17th February 2022

I am emailing regarding planning application A/268/21/PL by Caffyns to build a Volvo garage on Roundstone Lane.

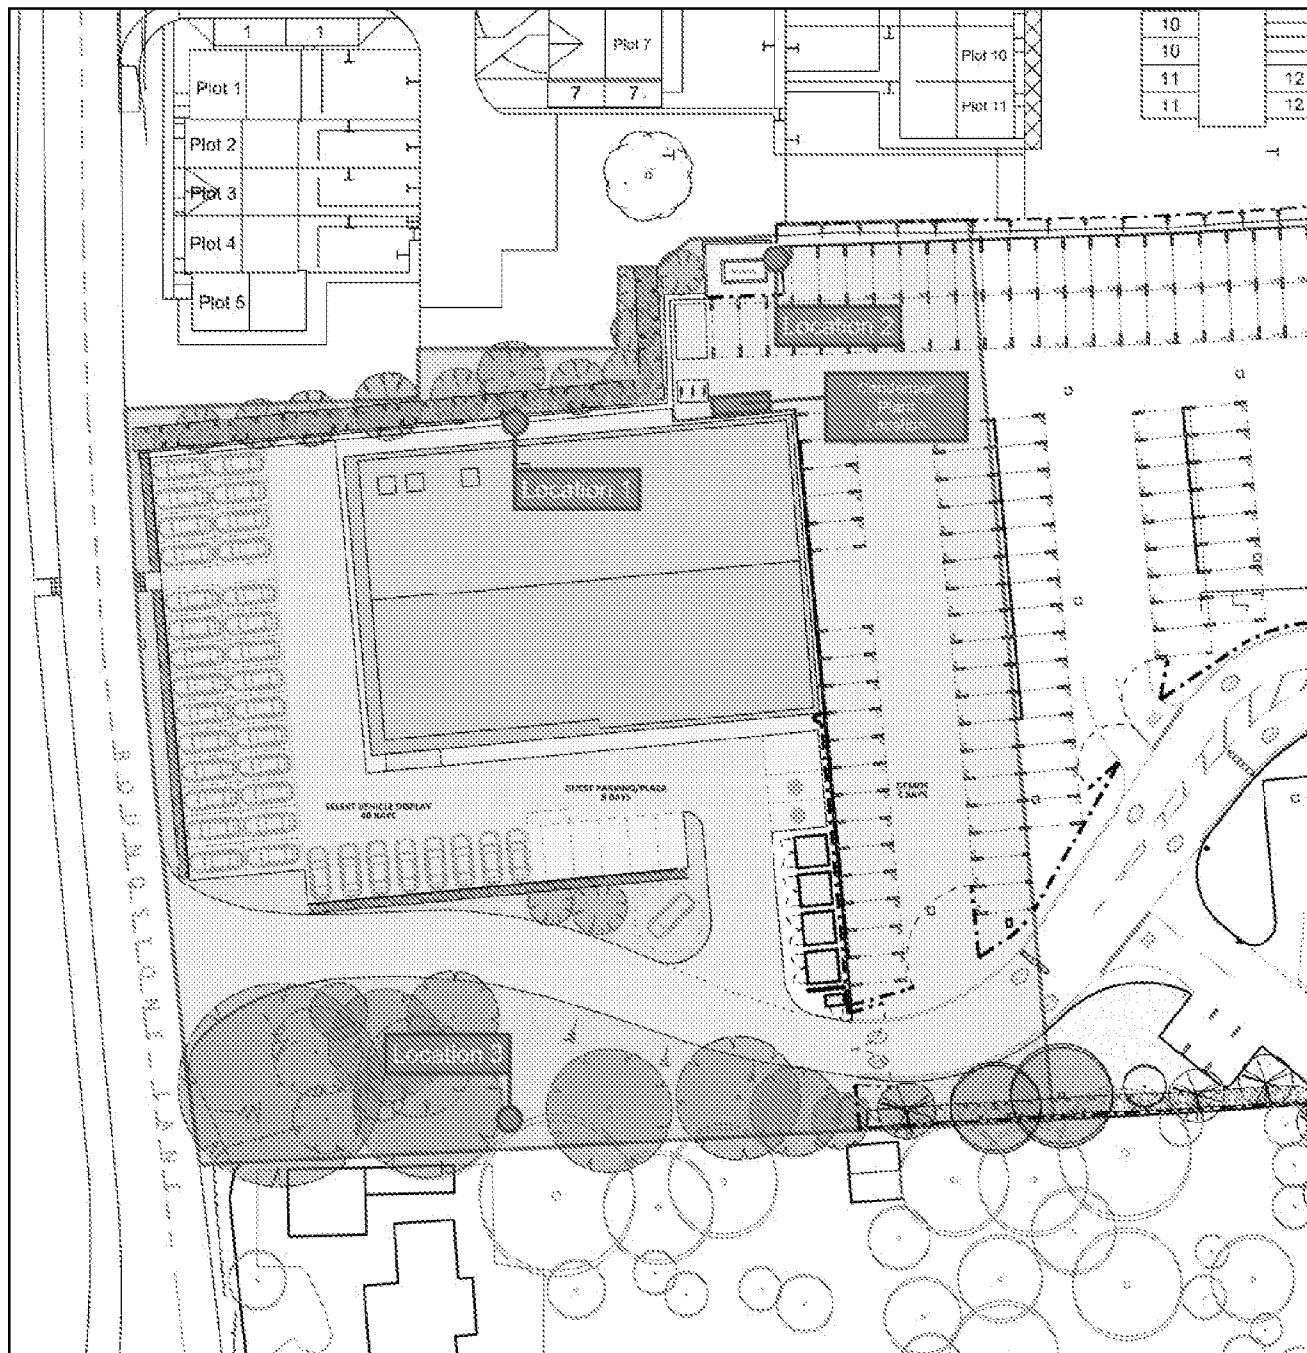
I have two objects for noise. First, is the proposal to put a condensing unit (highlighted in a red circle on the diagram below) a couple of metres from the southern border of Plot 7 (shown by the pink diagram lines) and Plot 11 (shown by the yellow diagram lines). It is unclear which unit will be placed there, either 89db or 65db, but either far exceed current noise levels. Furthermore, it does not mention if the unit near the residential fence of Plot 7 (12 Quiet Waters Close) will be making these noises all day every day, or if it is linked to the running of the workshop. I request further clarification, and for the condensing unit(s) to be moved further away from the residential boundaries and placed in an area that would not also impact another residence.

Key

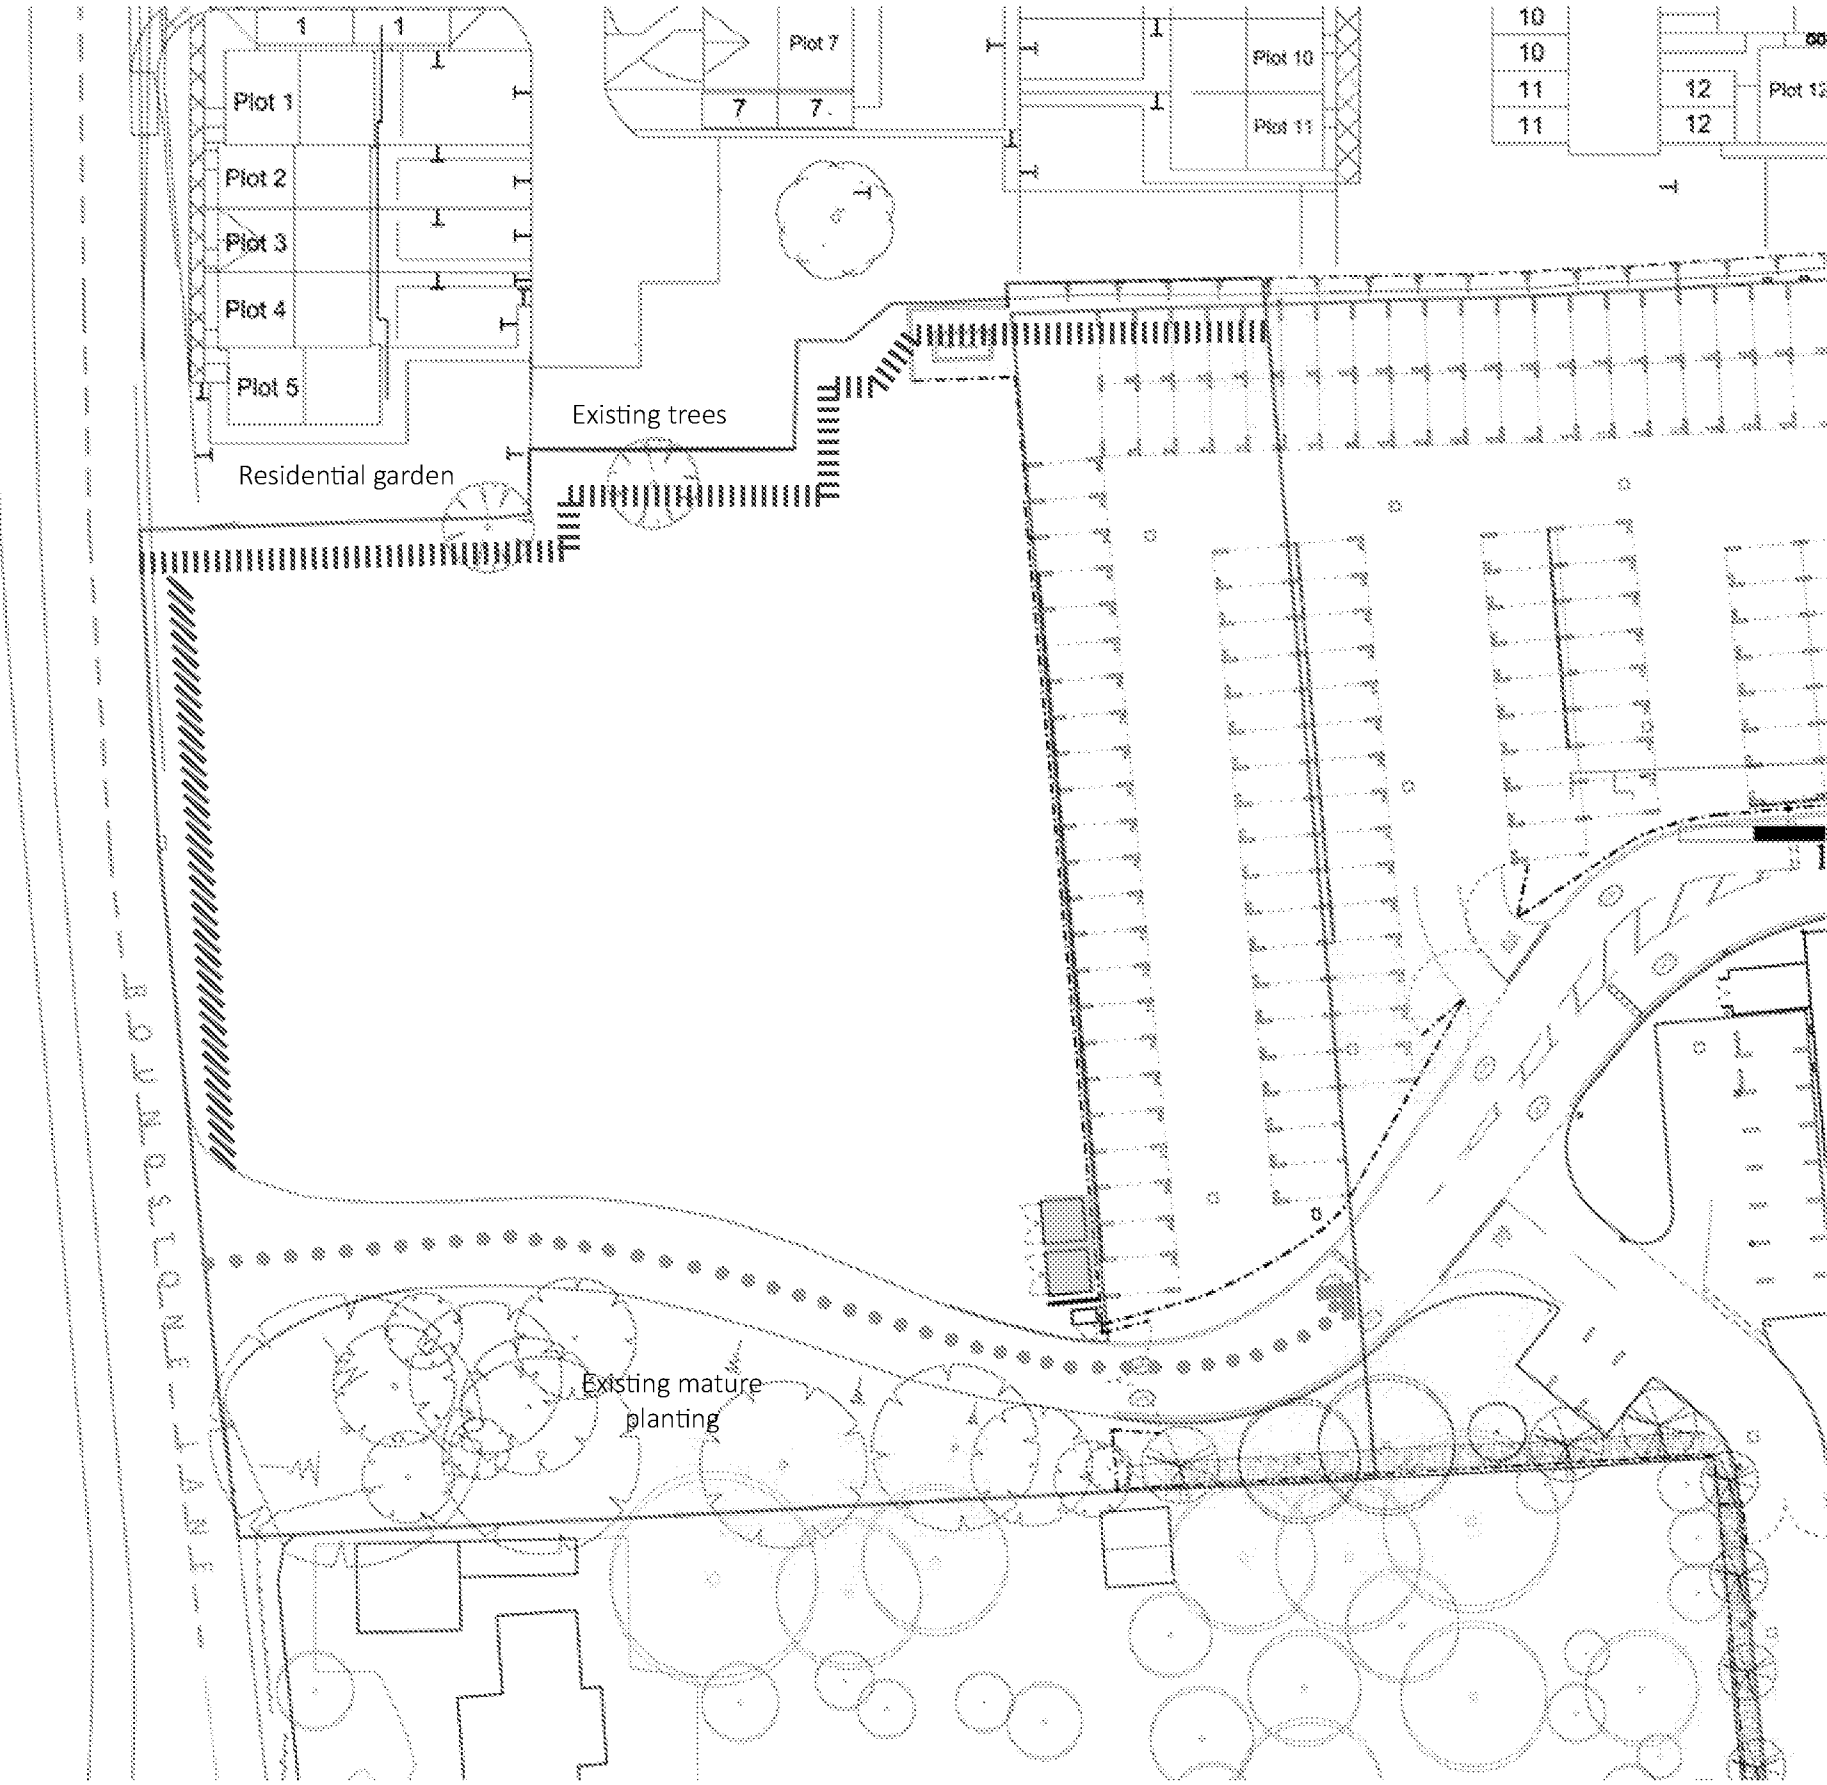
On the document Design and Access Statement - Rev P04 Figure Page 12 the existing site plan. While the garden is correctly marked for Plot 5 (2 Quiet Waters Close), the gardens for Plot 7 and Plot 11 are incorrect. The edge of their gardens runs right up to the southern boundary (on the opposite side of the fence to the gas box) and this has not been considered in the plans, designs or any of the external assessments (see comment about the condensing unit below). The design believes there is a thick line of existing trees. This is incorrect. The diagram below shows the correct garden boundaries; the red lines mark the boundary of Plot 7 and the blue lines show the boundaries of Plot 11.

1 - Proposed Site Context West Elevation
1 : 100

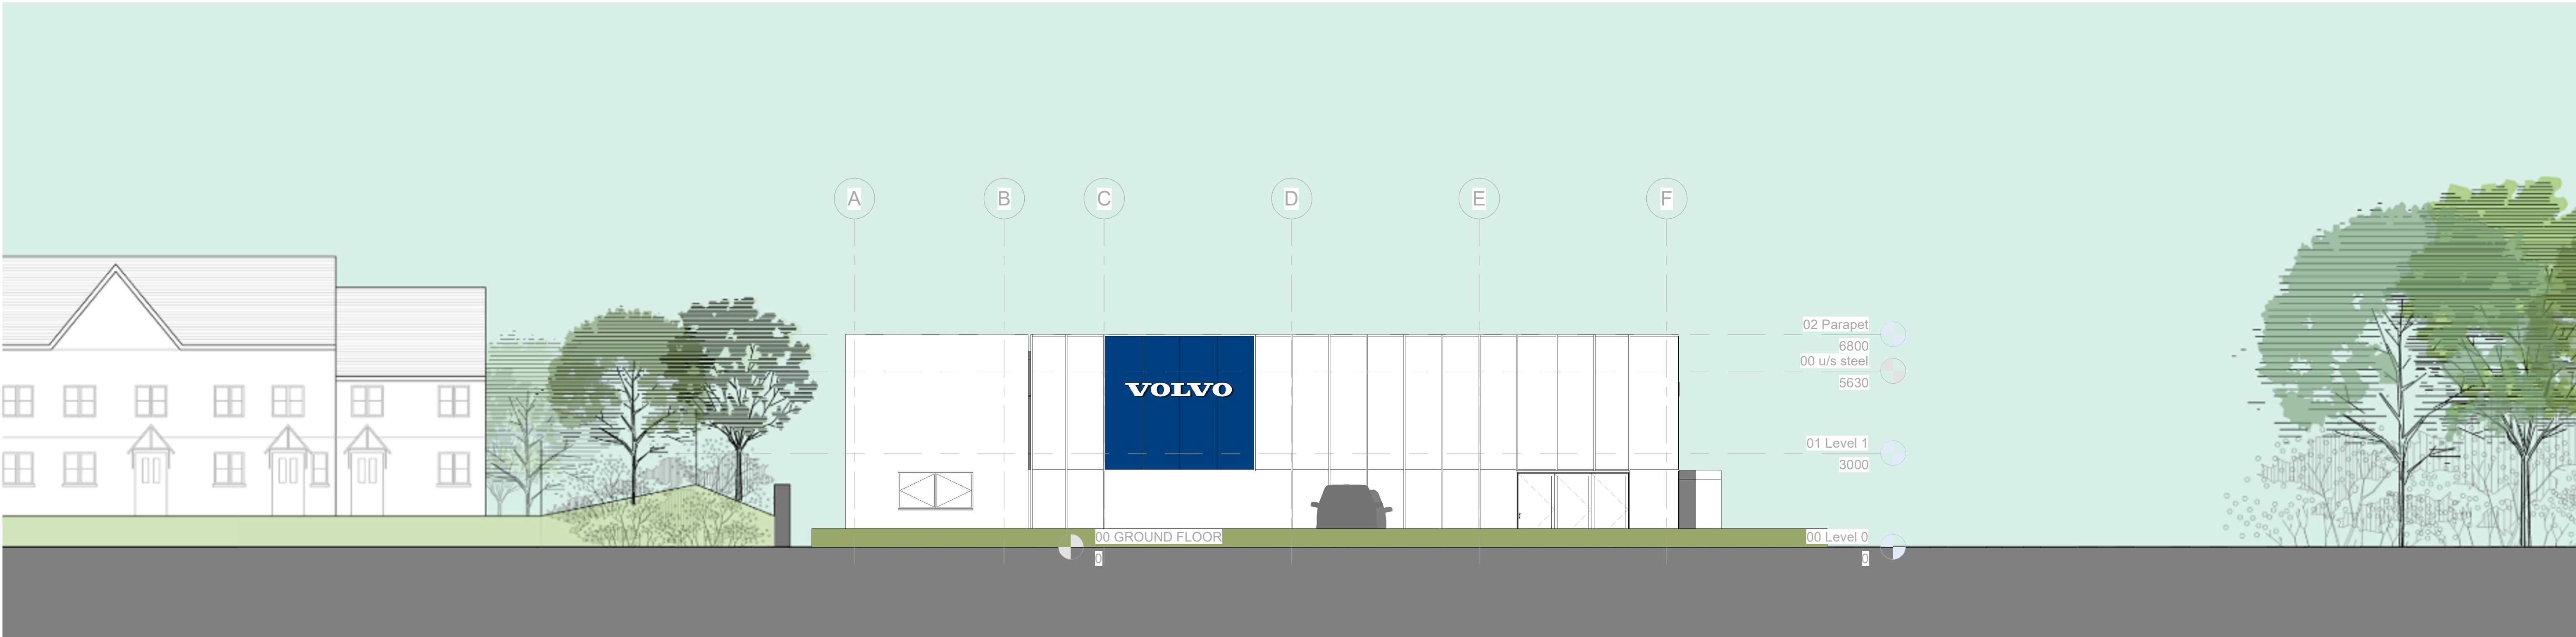
Furthermore, the document Proposed Site Context Elevation Dwg No 3661-SRA-XX-XX-D-A-05-005 Rev P02, from 19th January, incorrectly demonstrates the

current fence line between Plot 5 and the new development. The document suggests the trees are either existing or the current buffer; this is plainly not the case. There is also a large raised wooden fence that is not even referenced on the diagram. I believe this is to be covered by Mr Willcox's comment, on his correspondence on the 15th also regarding his border on Plot 5.
